From: Amanda Scholes on behalf of Planning.Responses
Sent: 14 January 2021 11:51
To: Planning Scanning
Subject: FW: Croft Works Site Access Driveway R197/20/out

From: Adam King [REDACTED]
Sent: 10 January 2021 20:22
To: Anita Gardner <Anita.Gardner@arun.gov.uk>
Subject: Croft Works Site Access Driveway

SITE PLAN 1:250

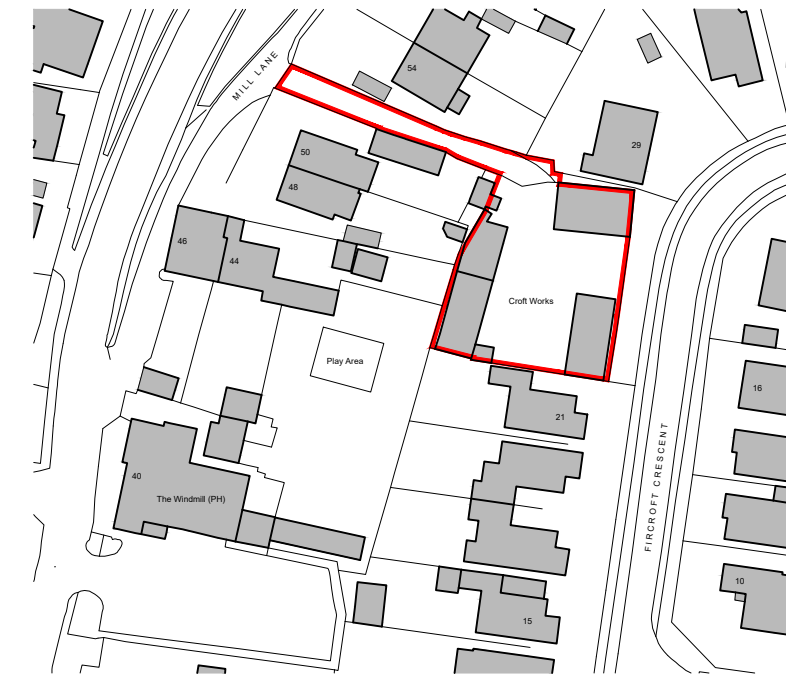
Hi Adam,
I acknowledge receipt of your e-mail and photos which will be added to the application and the additional information will be included in a Committee report update . Please can you provide a revised site plan /extract site plan to indicate the measurements you have noted?
Regards
Anita Gardner

Broadly speaking, the width of the entrance point is very close to the noted 4.65m at around 4.5m, and there is the potential to revise the northern fence slightly to remove the concrete posts and renew the fence to a higher quality one. There is a pinch point at around the centre of the access driveway where this reduces to 3.3m wide. At the end of the driveway the dimension measures 3.85m to the timber post which is slightly less than the 4.1m on the title plan.

What did you want to do regarding the dimensions on the Site Plan? We can adjust it accordingly, noting the above comments, so that it is as accurate as possible for the next Committee meeting.
